GASCOYNE CECIL
ESTATES

6/2018/2497/FULL

1-5 PARK STREET, HATFIELD, AL9 5AT CHANGE OF USE TO OFFICES
PLANNING APPLICATION COMMENTS

Proposed site plan

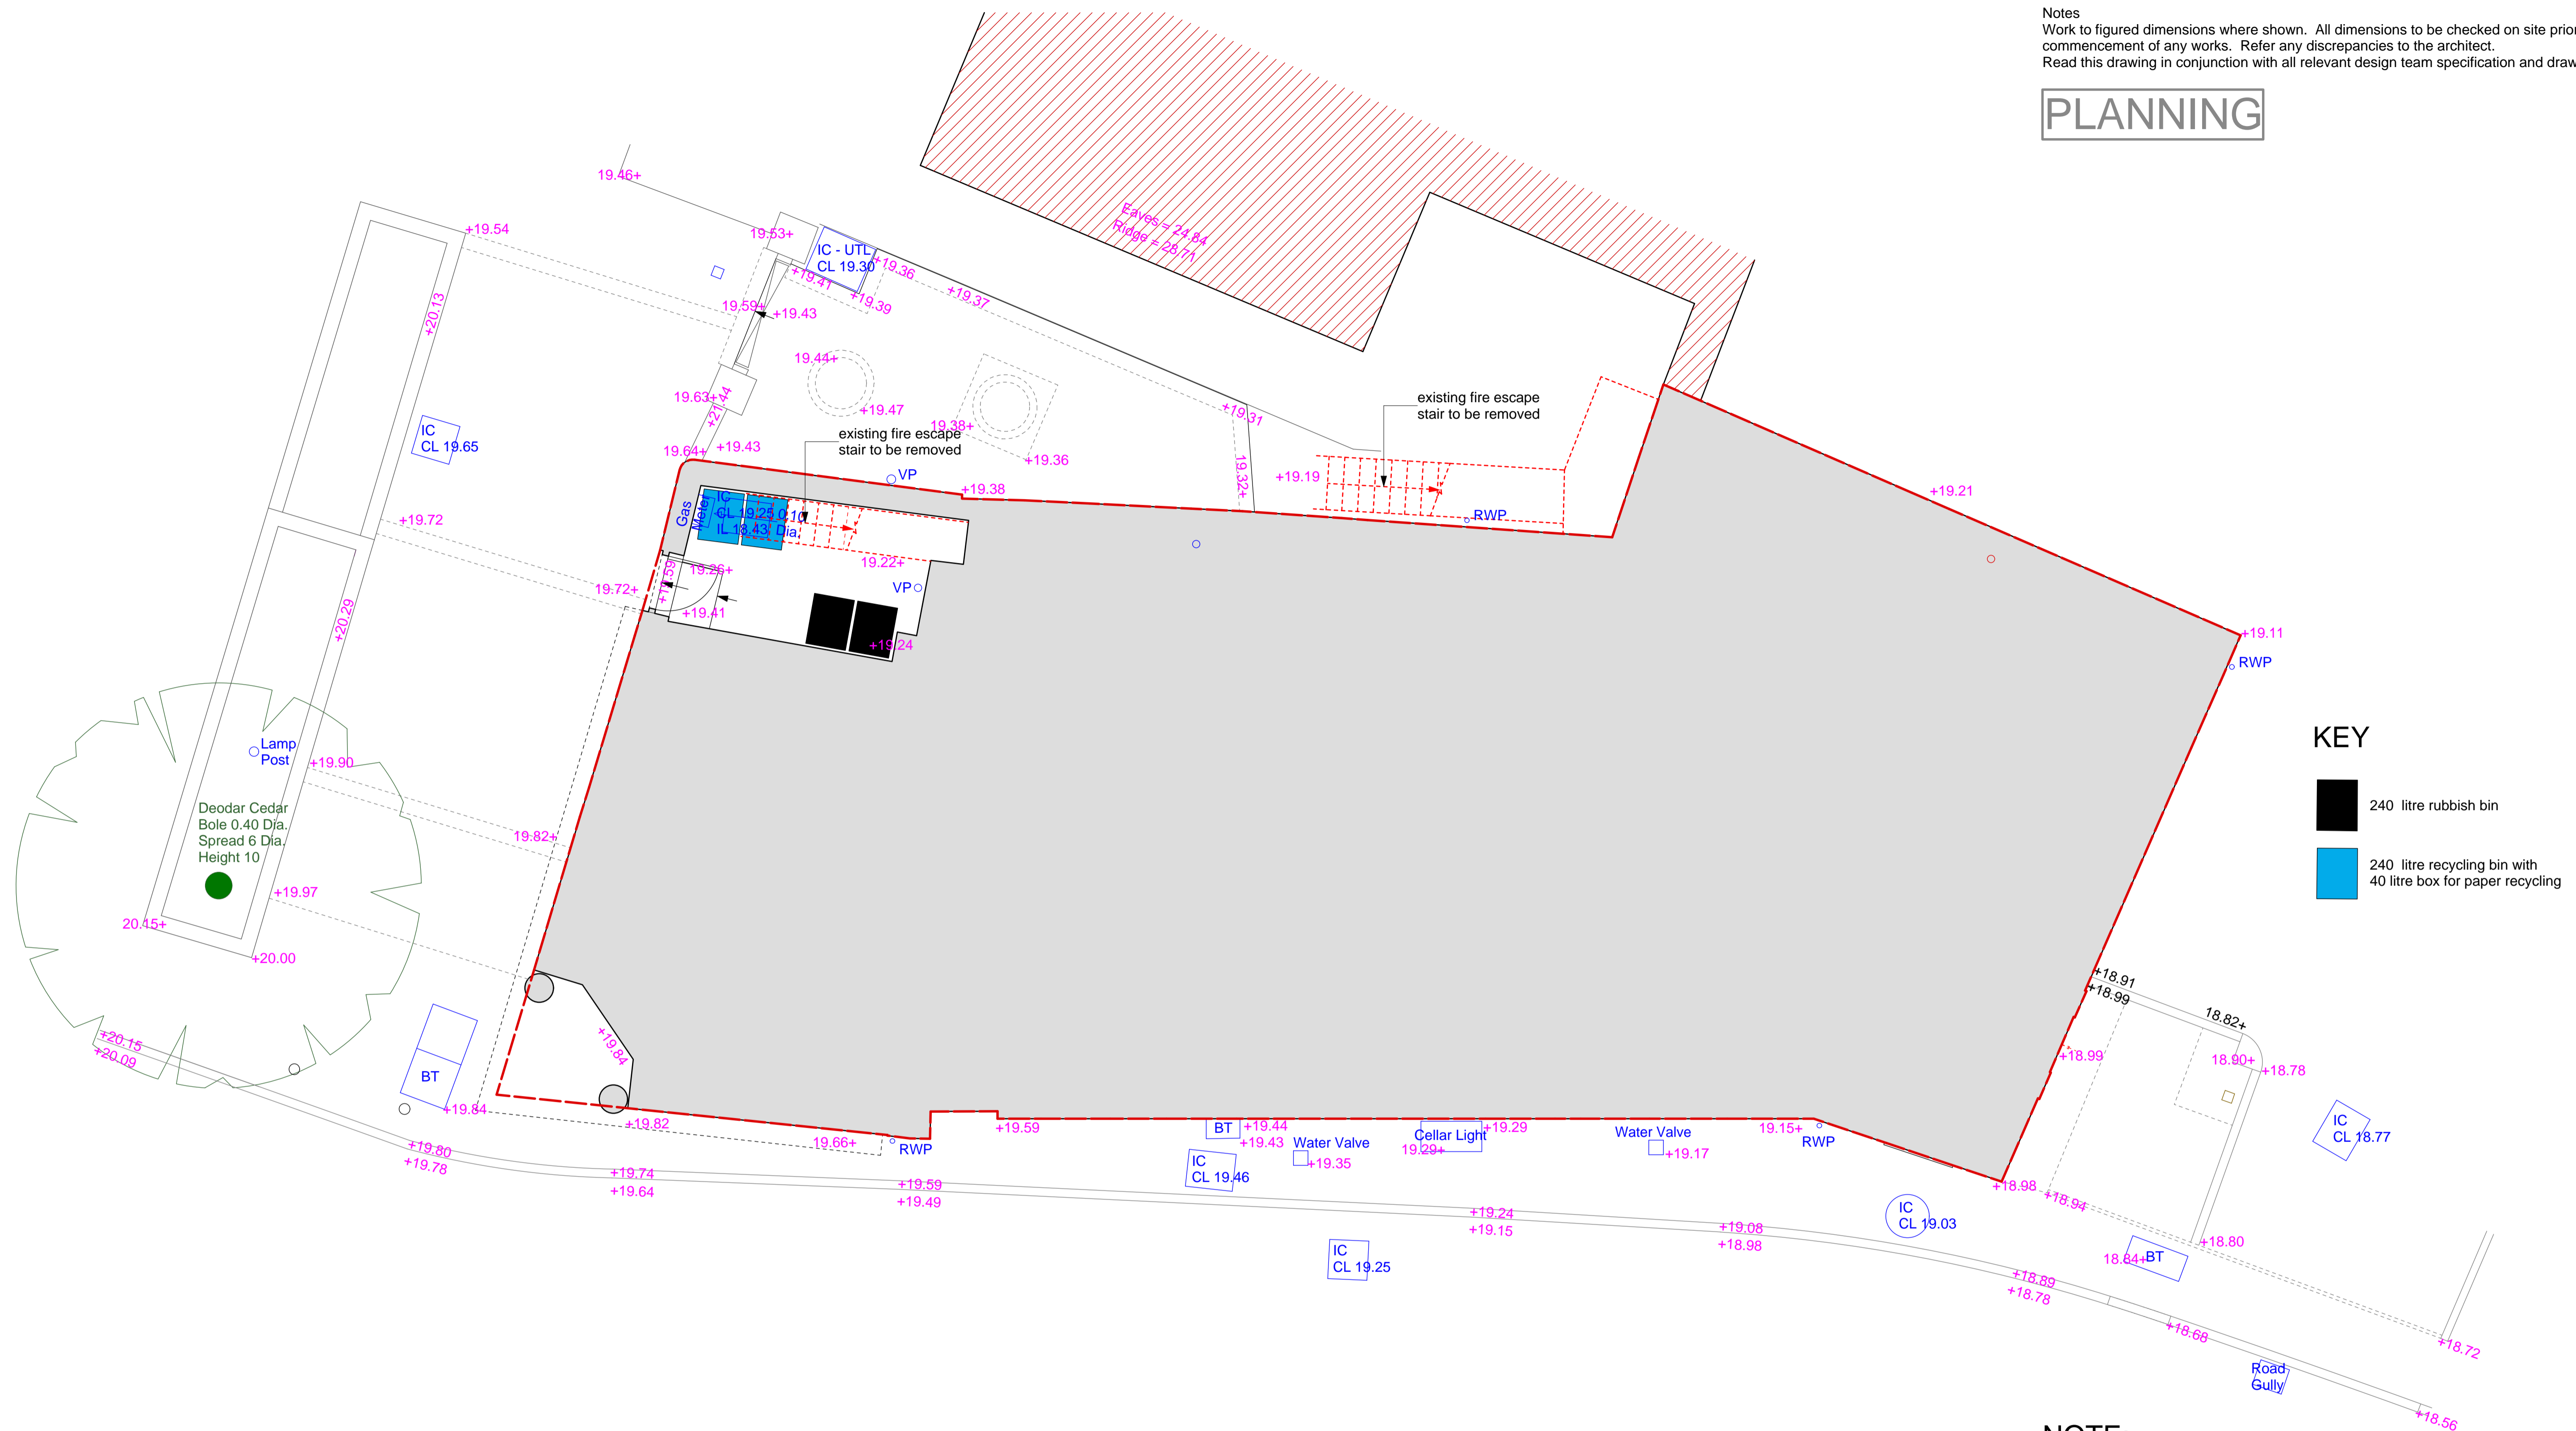
- 5) Noting the site constraints and the virtual lack of external curtilage, the lack of areas for bin and bike storage is of concern. Noting the severely constrained car parking in the locality, the applicant ought to be encouraged to ensure development supports sustainable modes of transport including cycling, car sharing, etc. Whilst the former office use represented a theoretically higher level of vehicle movements, it must be noted that a considerable number of years have elapsed since the building was occupied at anything like its full potential. Any suggestion therefore that the proposed use represents a reduction in vehicle movements is, in part, misleading.

Proposed elevations 6 + 7

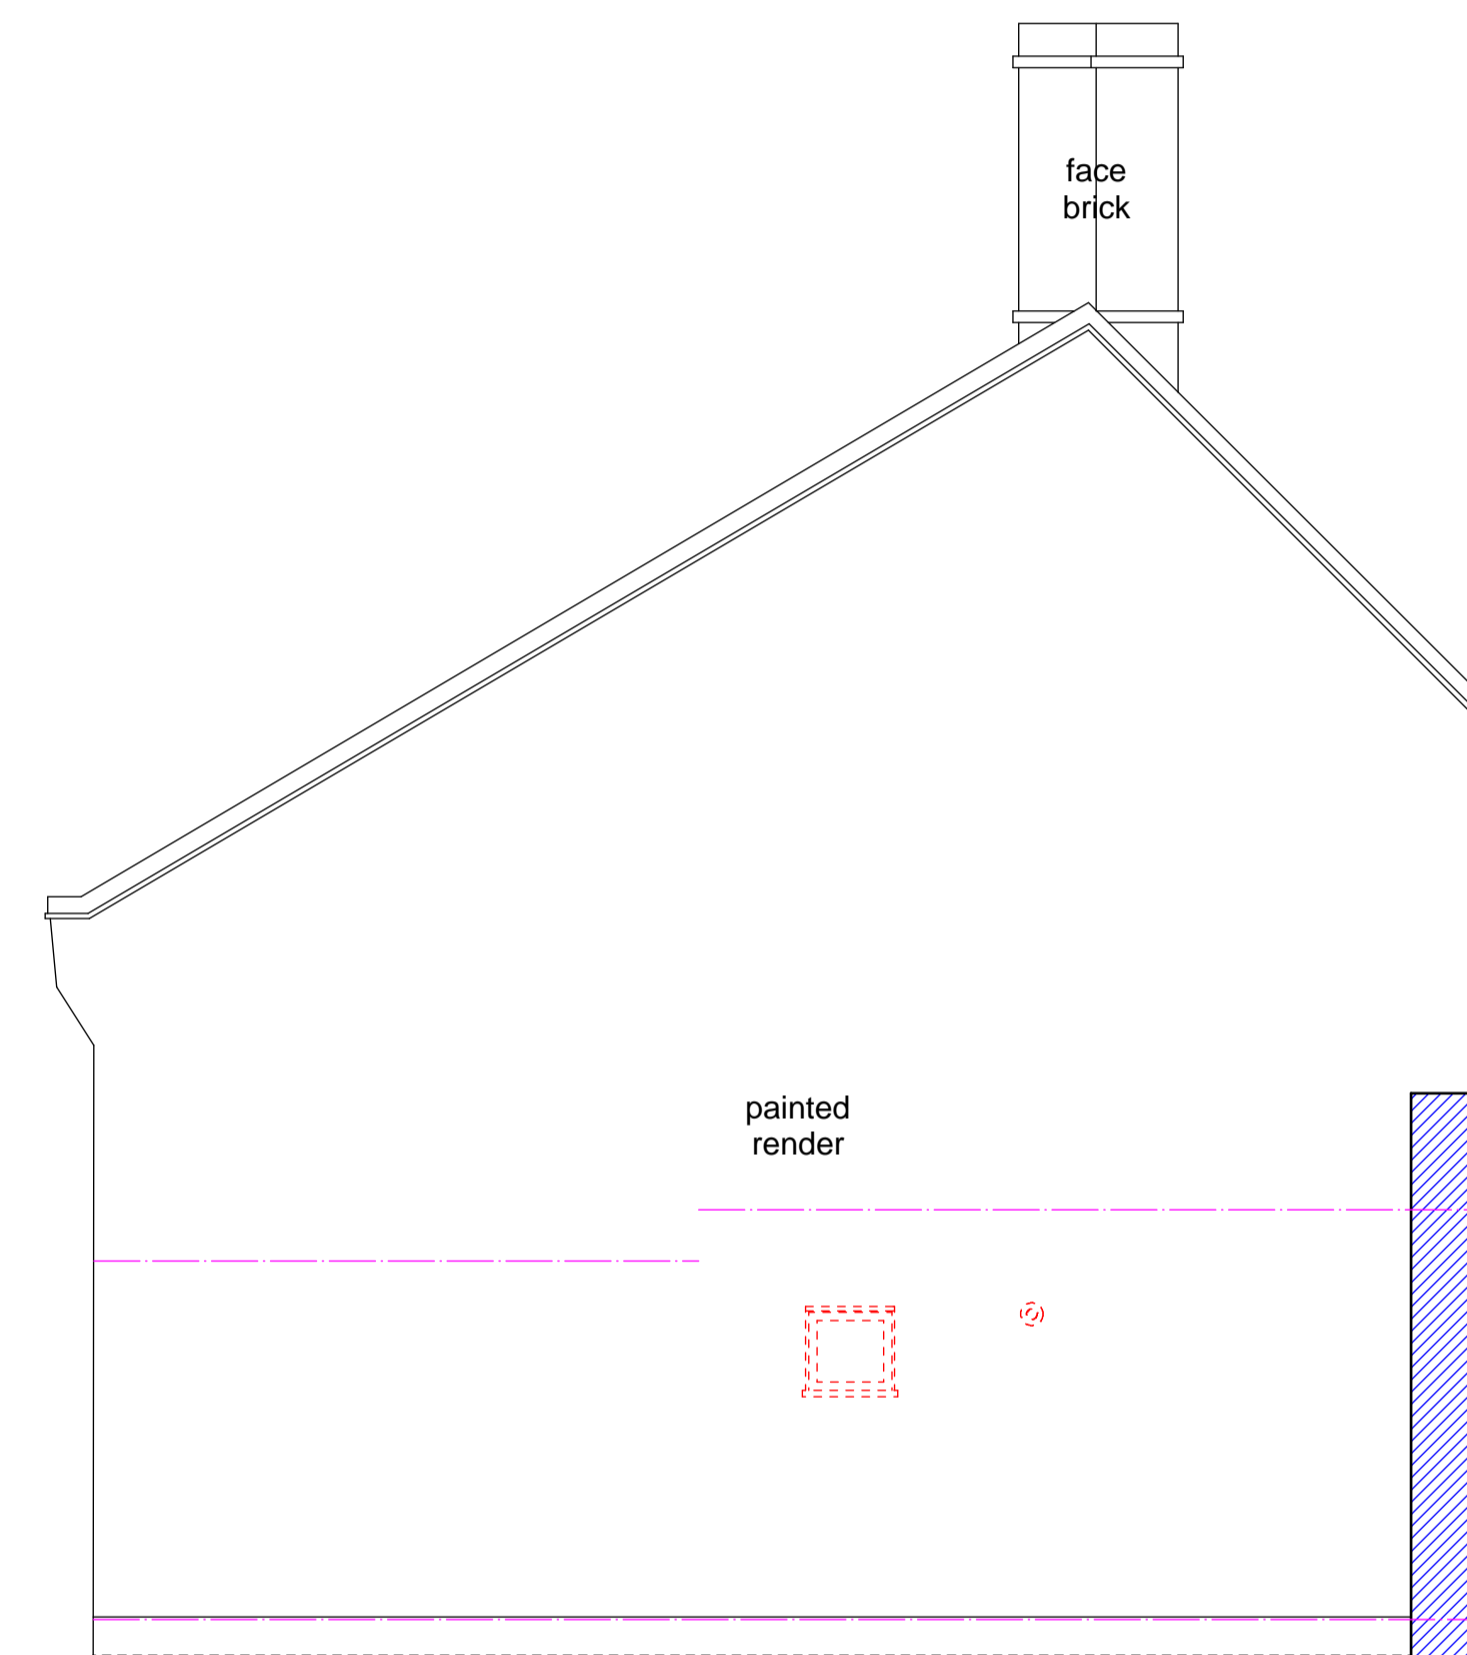
- i) Details of all replacement joinery should be separately approved by the Conservation Officer including all sections and moulding details.
 - ii) The building should be properly recorded and subject to a full photographic and measured survey prior to the removal of any existing fabric.

Proposed basement ceiling treatment

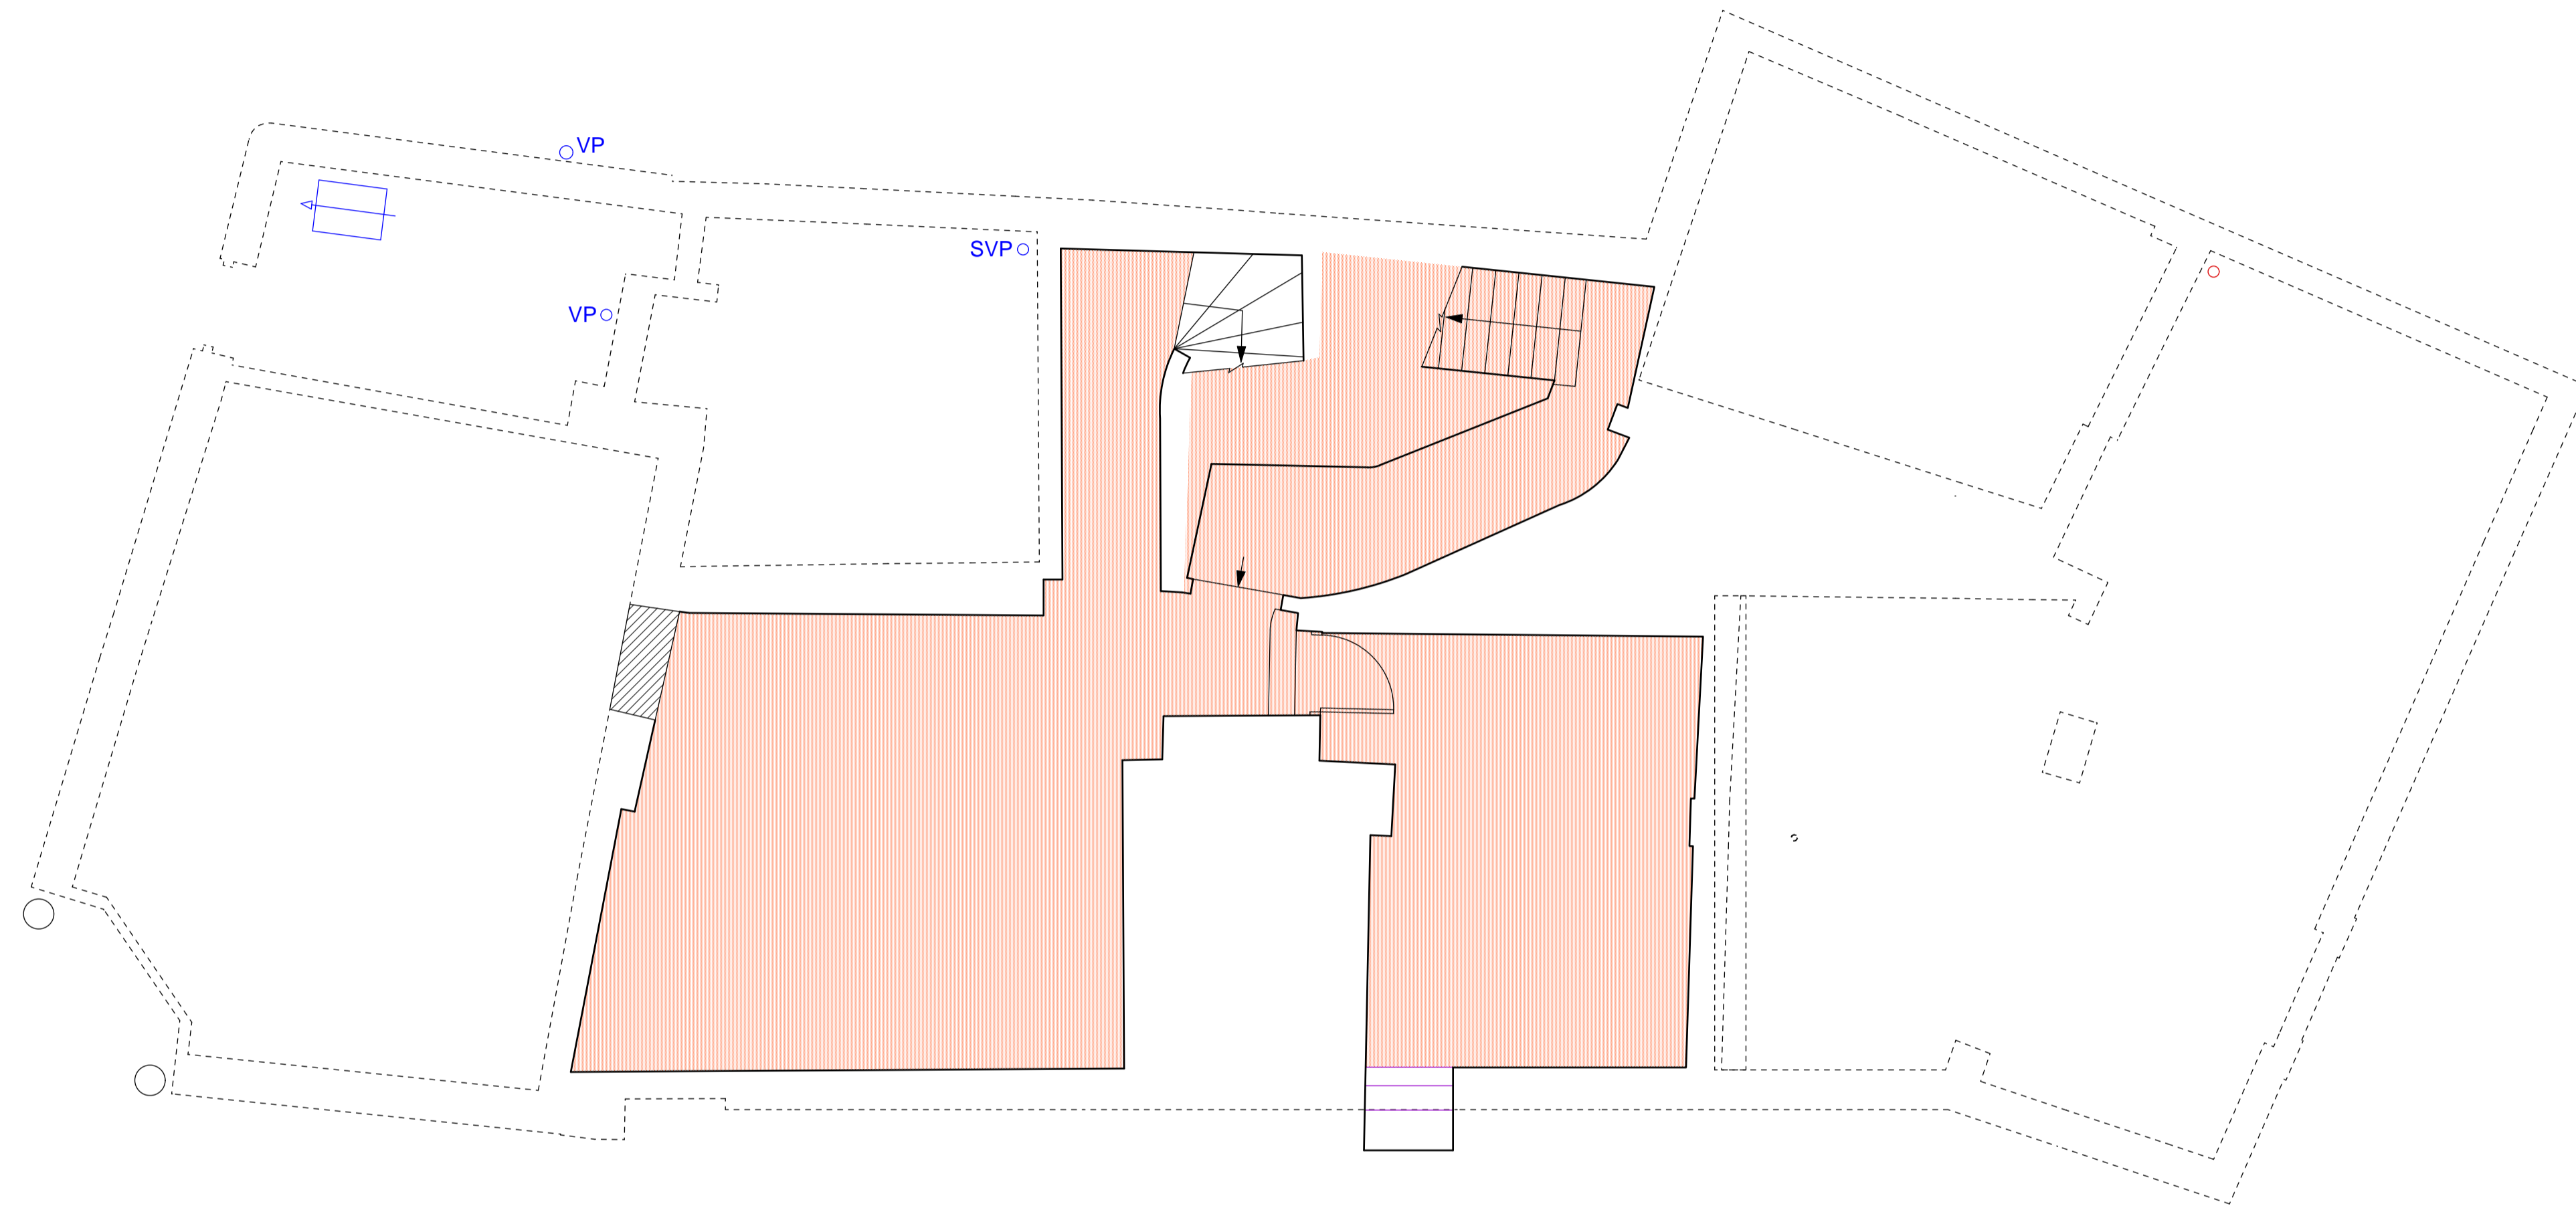
- 3) Noting the above, and whilst partly an issue of Building Regulations, one questions the challenges associated with subdivision of an older property whilst simultaneously meeting current requirements for good fire and acoustic performance. This can be especially problematic when

noting the balance to be made between conservation, use of traditional building techniques and acceptable risk management / performance.
